From: Webster, Gary [REDACTED]
Sent: 15 May 2020 15:22
To: Jones, Julian D; Maria Tomalova
Cc: Gateley, Jon
Subject: RE: BN/18/20/PL, Former Brooks Nursery
Attachments: 4482-506(D) S104 Layout Phase 2.pdf; 4482-510A Foul Outfall Rising Main Details.pdf; 4482.502E Phase 1 Section 104 layout.pdf

From: Jones, Julian D [REDACTED]
Sent: 15 May 2020 14:59
To: Maria Tomalova <Maria.Tomalova@arun.gov.uk>
Cc: Webster, Gary [REDACTED] Gateley, Jon [REDACTED]
Subject: BN/18/20/PL, Former Brooks Nursery

| Drawing No. |          | 4482:510                                    |          |

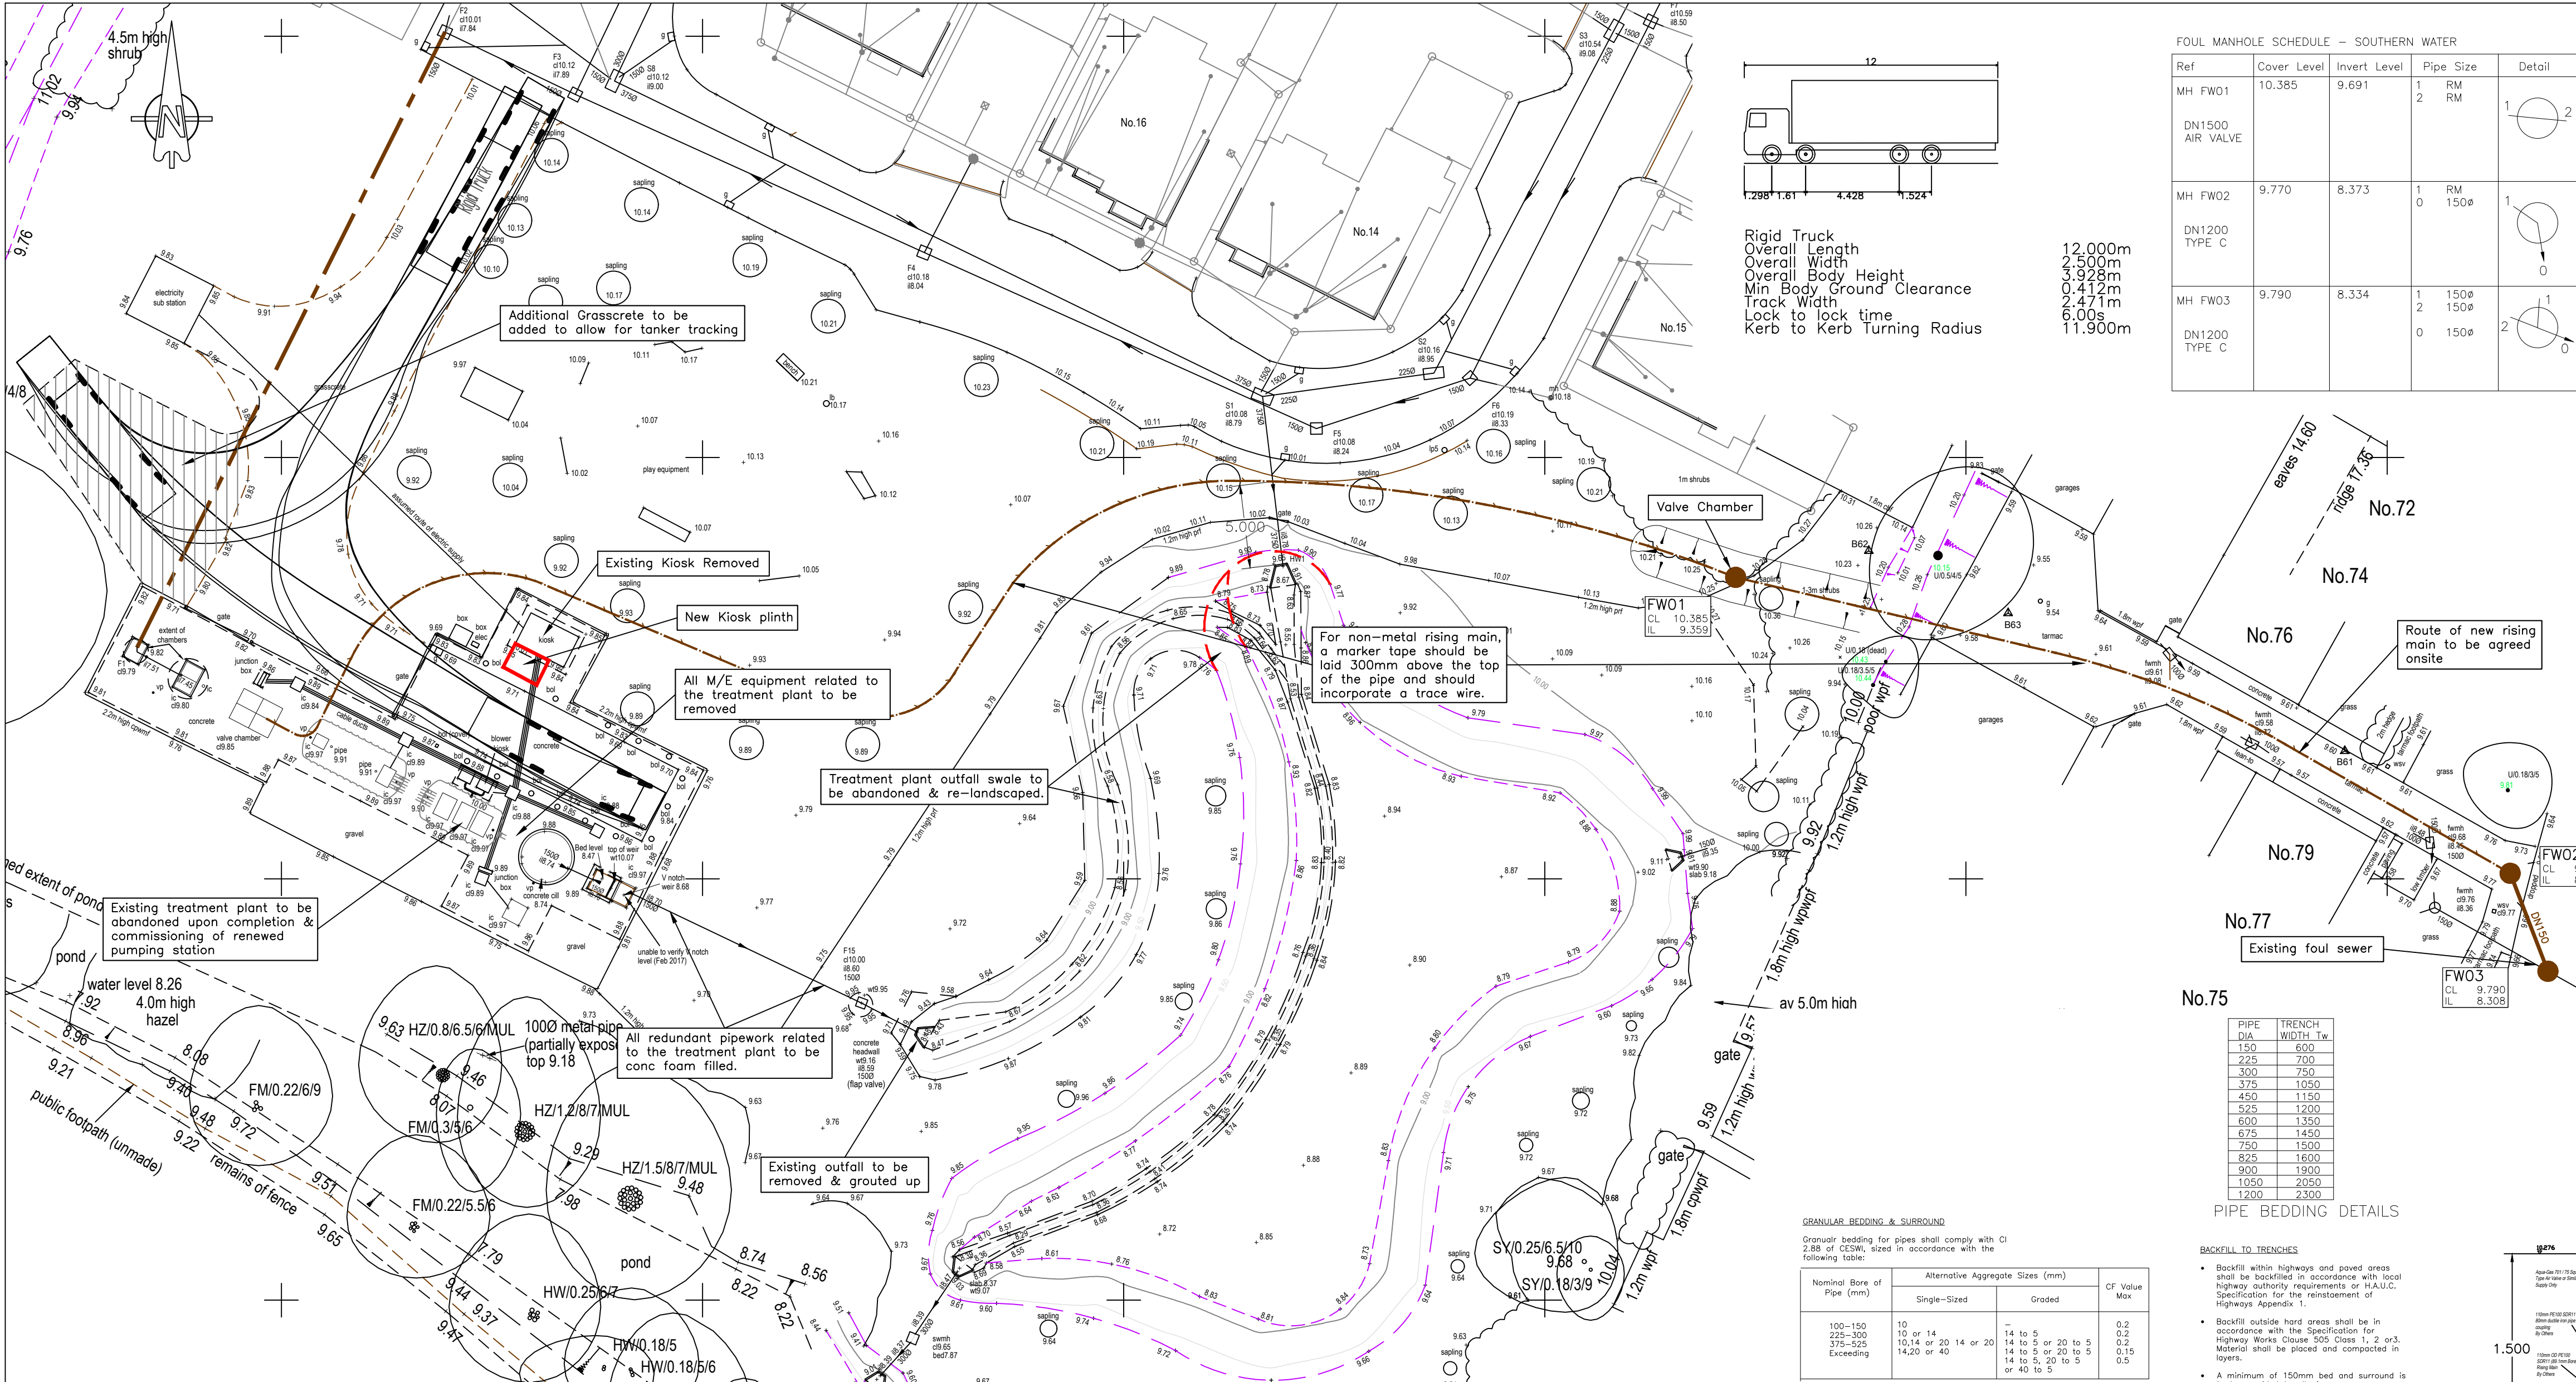
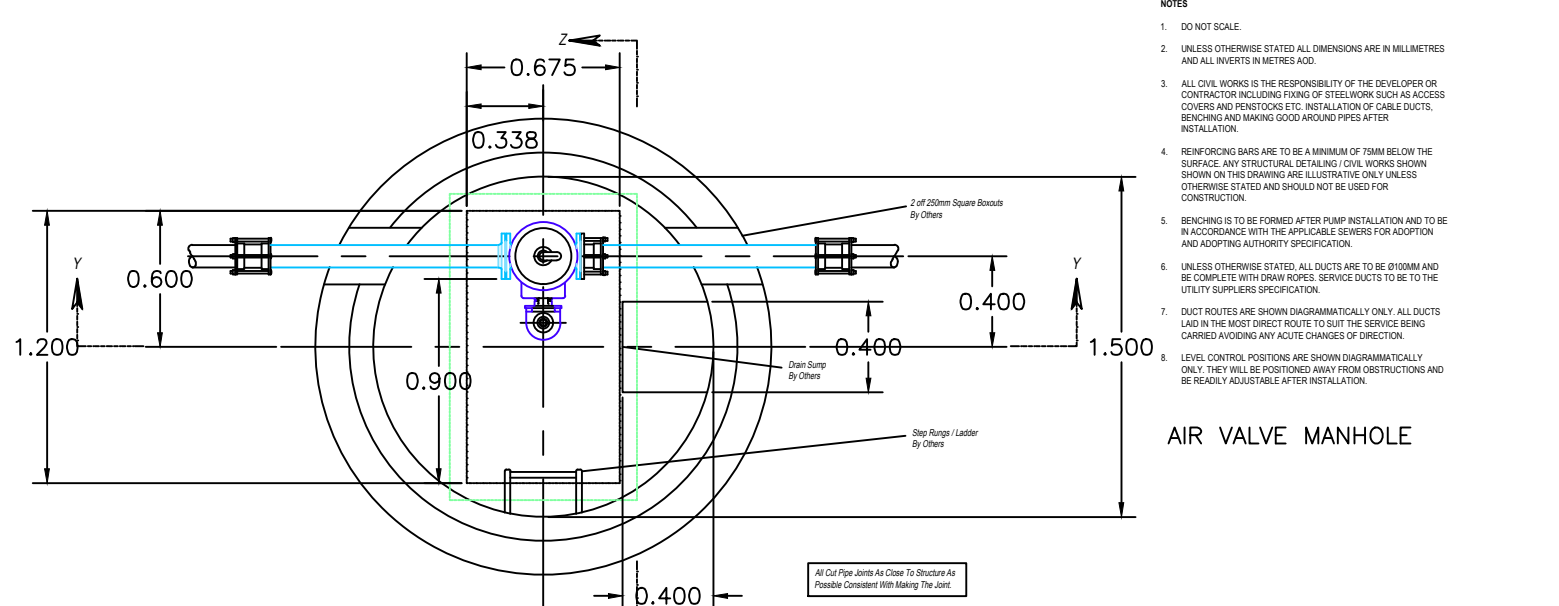
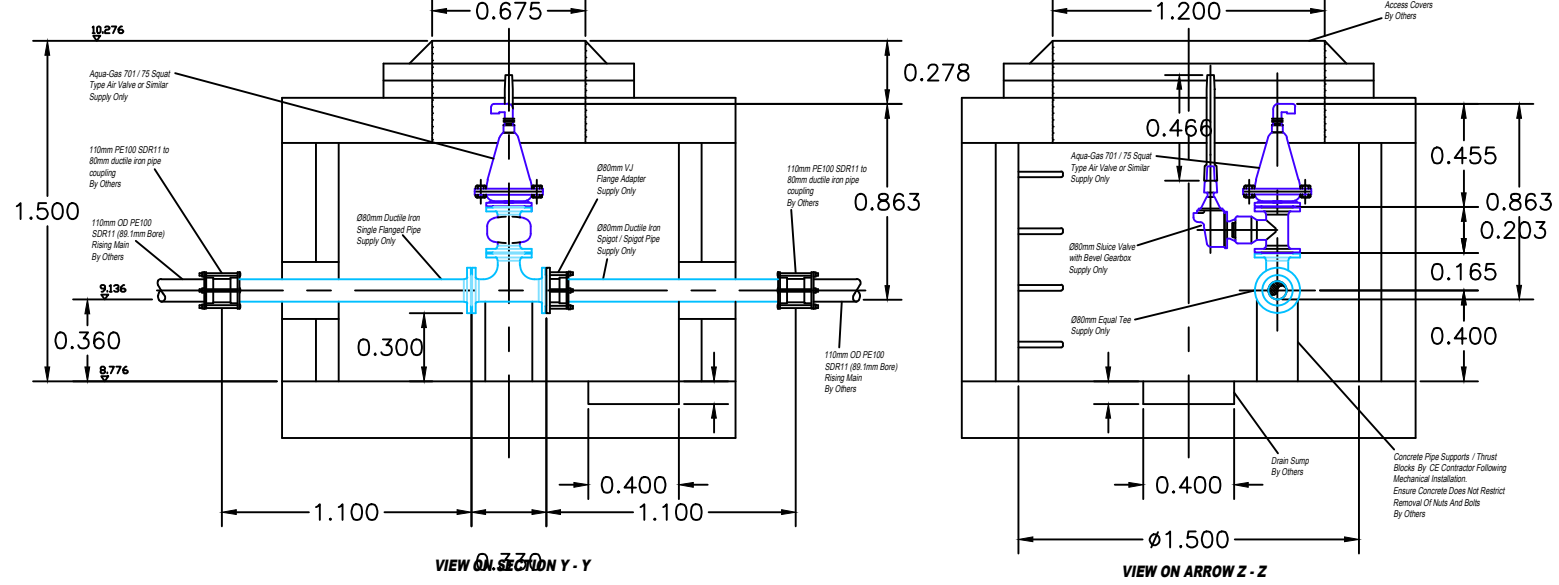
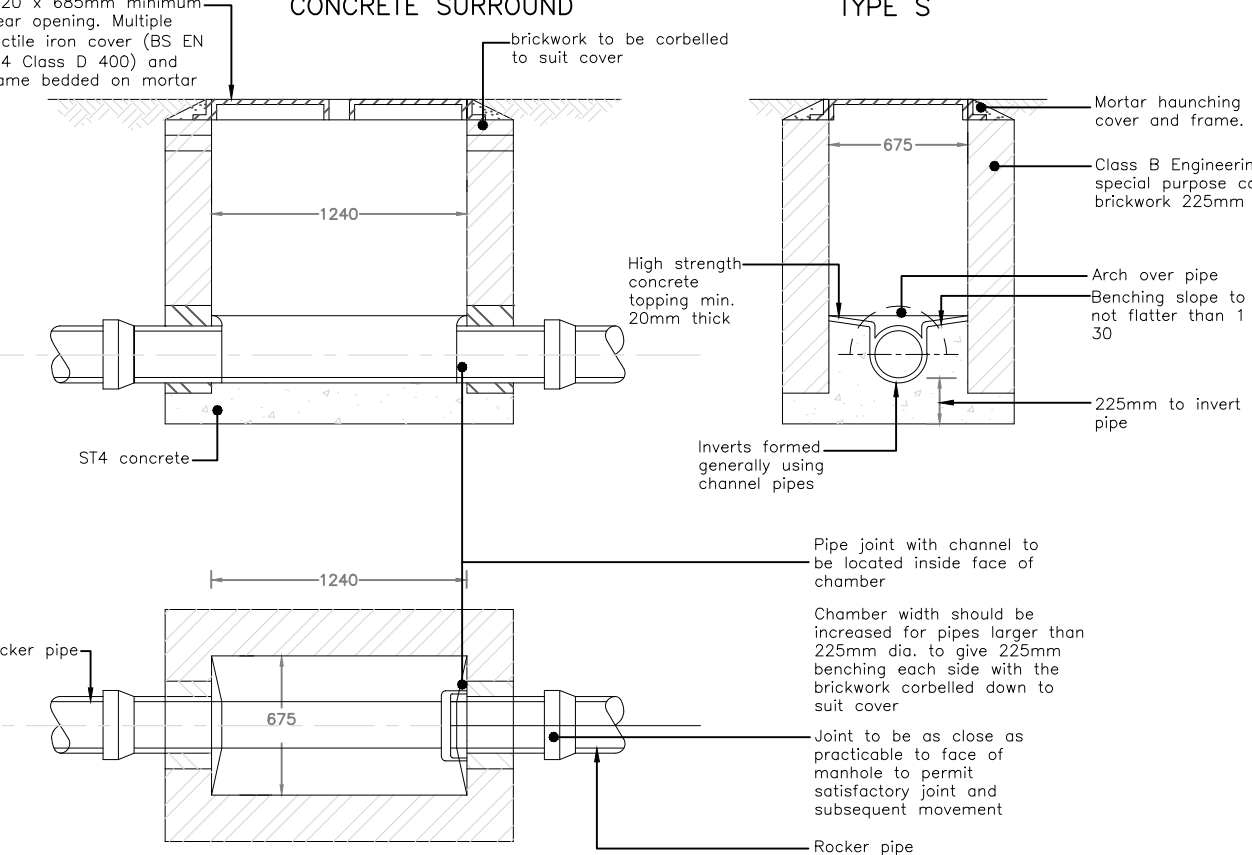
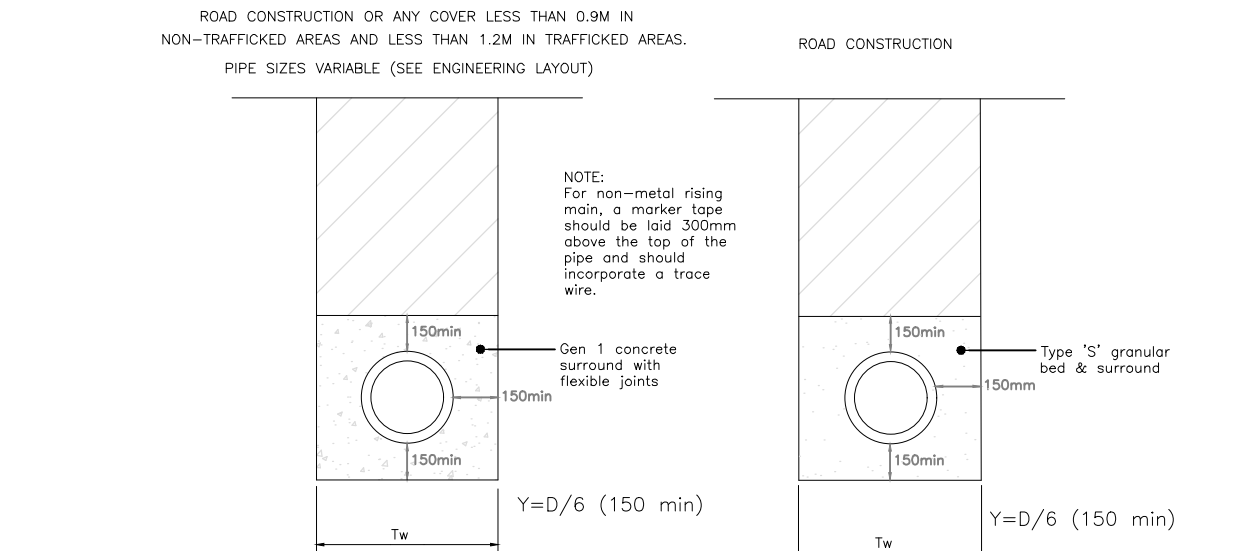
- a) The open channel/ditch in which the sewage treatment plant discharges into at present, before it connects into the suds pond, is proposed to be infilled.
The applicant will need to provide written confirmation with supporting calculations to prove that the storage for surface water within the suds system is not compromised as a result.
- b) Where the proposed rising crosses the incoming surface water outfall to the pond and the known land drain running parallel to the eastern boundary of the development, the applicant should provide a longitudinal section to prove no impact on these pipelines.

Finally, the long section requested was already shown on drawing no, 4482.510A , which I attach for reference along with the other engineers drawings which were agreed at the meeting
